Subject: R-6 Small Infill Design Review – 31 Fore Street

Written by: Caitlin Cameron, Urban Designer

Date of Review: Friday, March 11, 2016

1 ELEVATION - SIDE - WATERVILLE ST

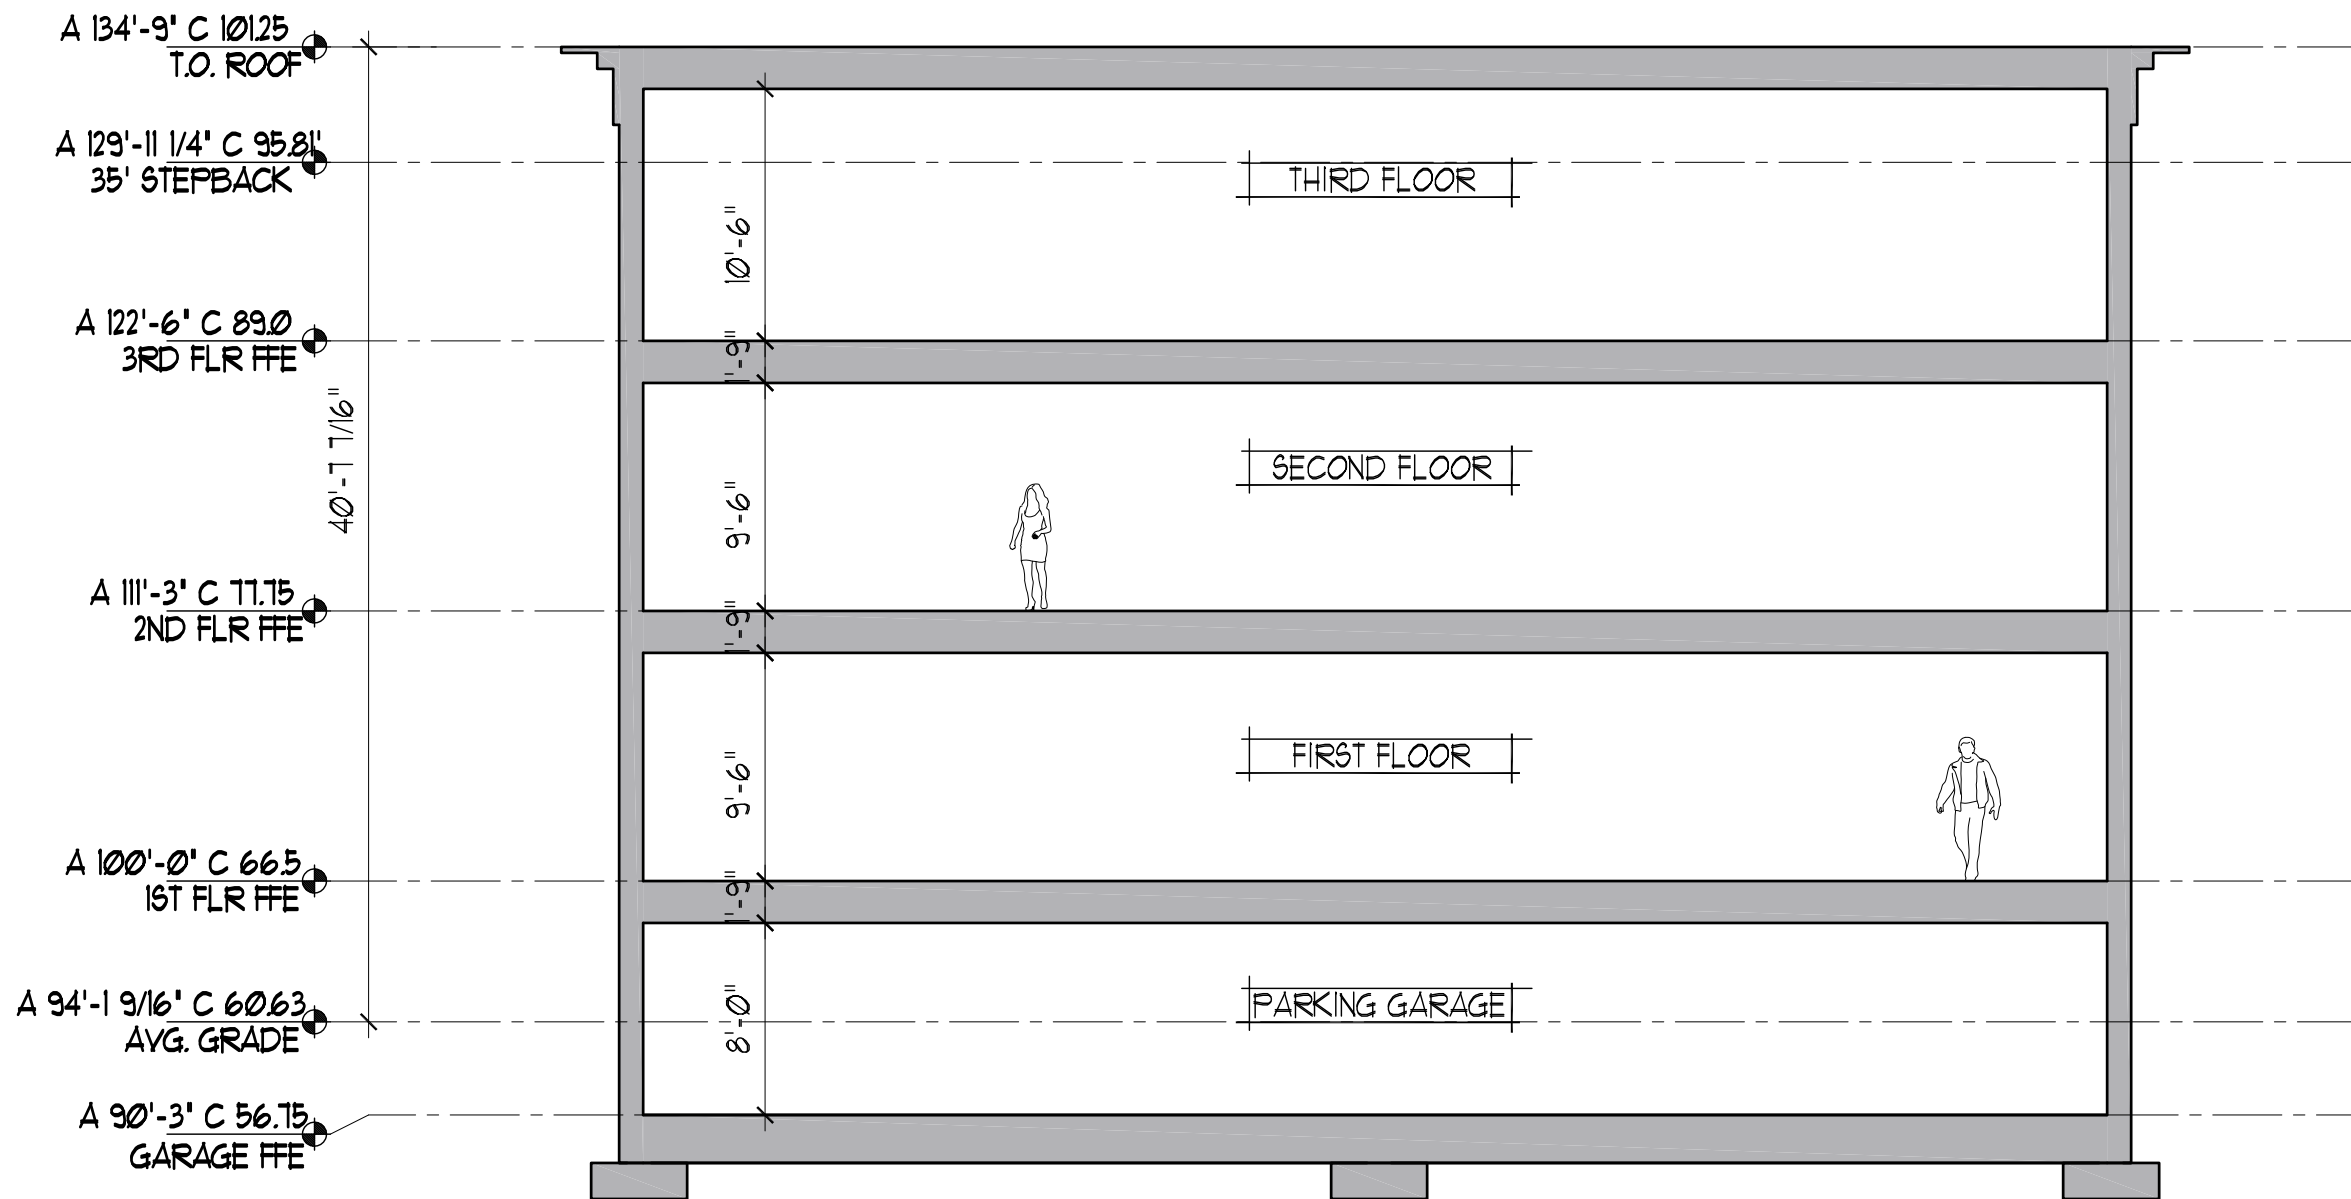
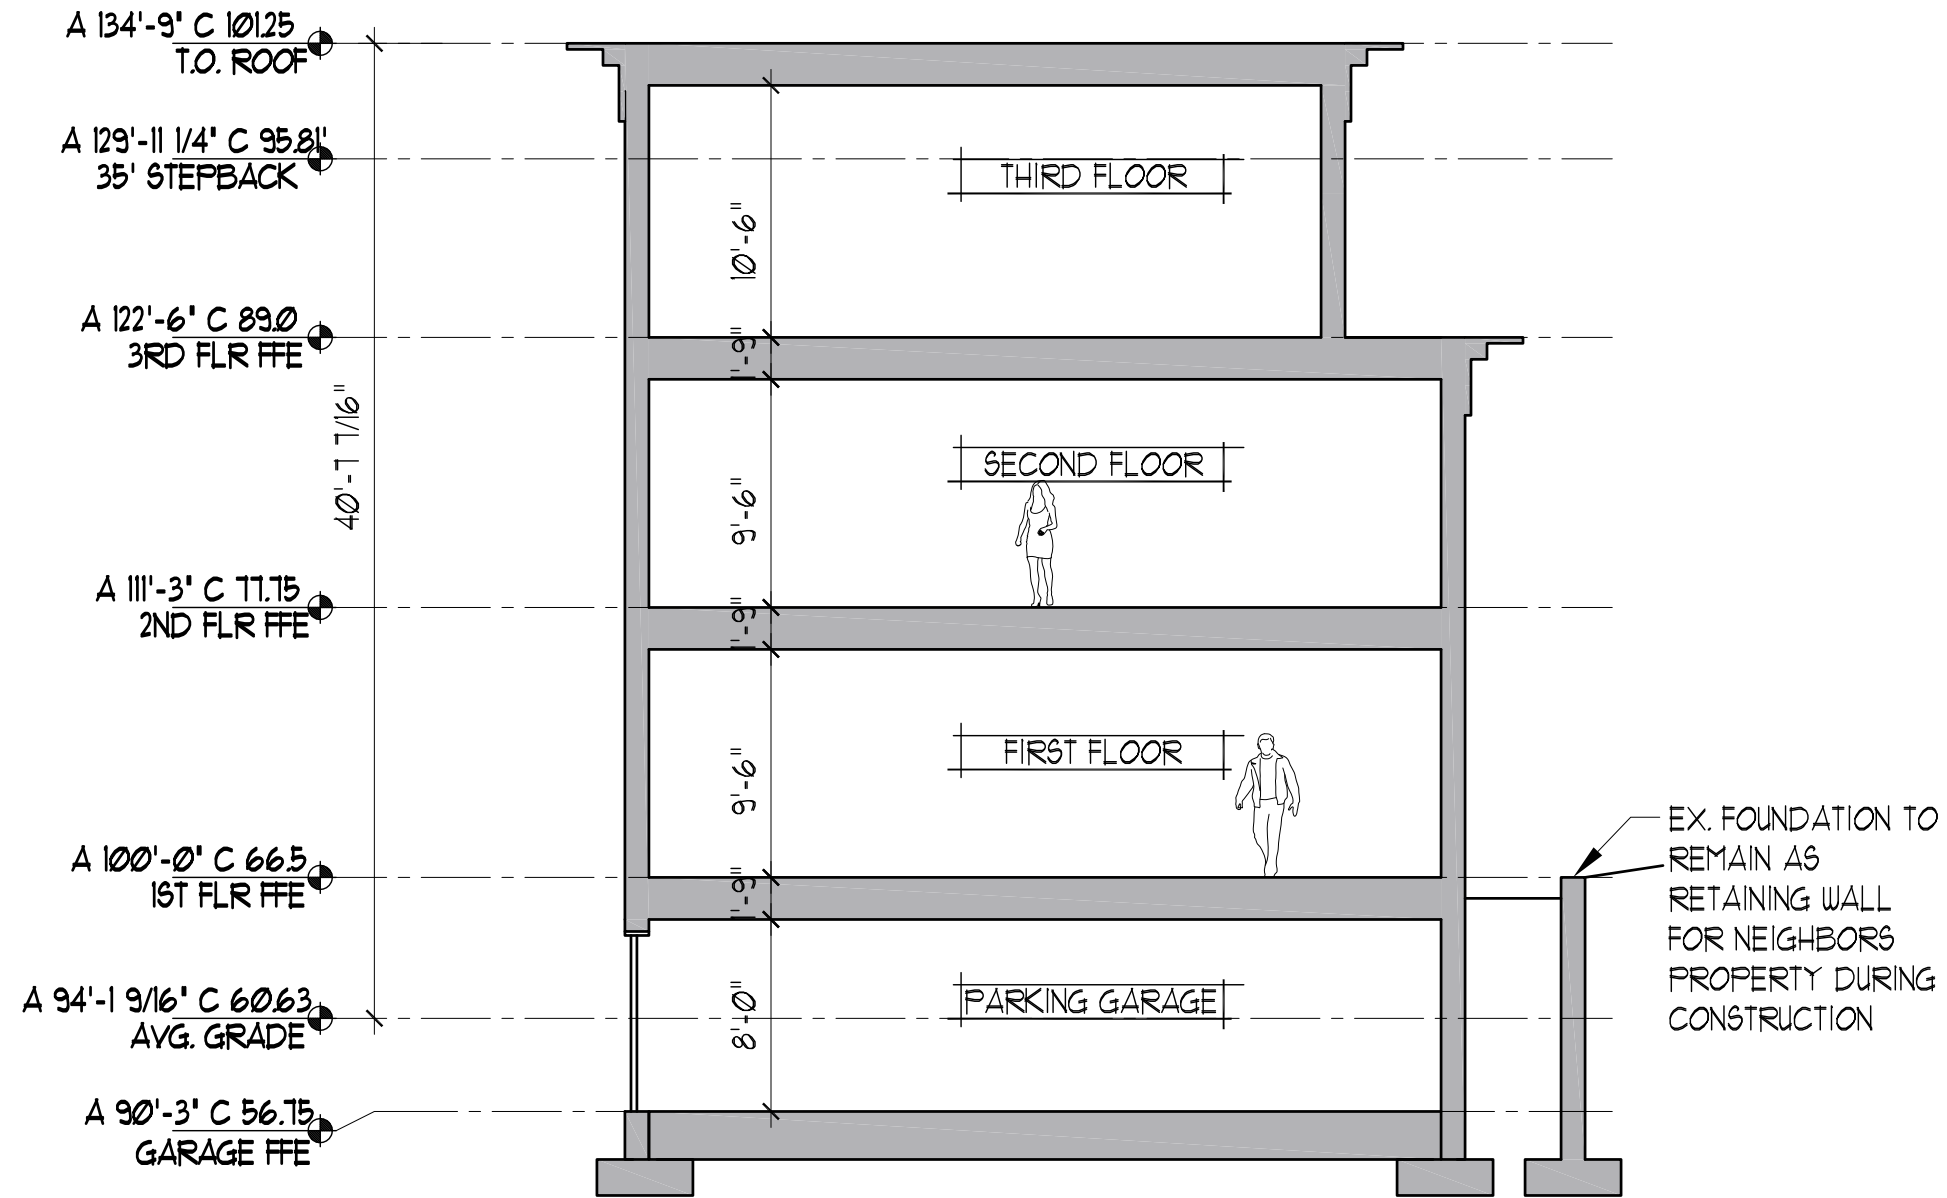
- **C-1 Entrances:** It is not clear which of the two entries is considered the main entry – indicate which entry will be the main entry and then make that entry comply with the standards. *Emphasize and orient the main entrance to the street. The main entrance of the structure shall either face the street . . . or be located on the side and be accessed by a covered porch that extends to the front of the building, at the primary street frontage.*
- *C-2 Visual Privacy:* Not applicable
- *C-3 Transition Spaces:* The project uses a side entry, canopy, and a vestibule for transition space.

- *F-4 Delineation between Floors:* The windows, balconies, and material changes delineate the floors.
- ***F-5 Porches, etc.:*** There is no issue with obscuring architectural features – **if the side entry is the main entry then the entry needs to become more of an architectural feature, especially to make it visible from the street.**

- ***F-6 Main Entries:*** **The main entry is not adequately emphasized. A side entry requires indication at the street – improve the visibility of this main entrance with elements such as an extended canopy or porch toward the sidewalk. If the Waterville Street entry is to be considered the main entry, then additional emphasis should be created whether with a canopy, lighting, building signage or other method.**
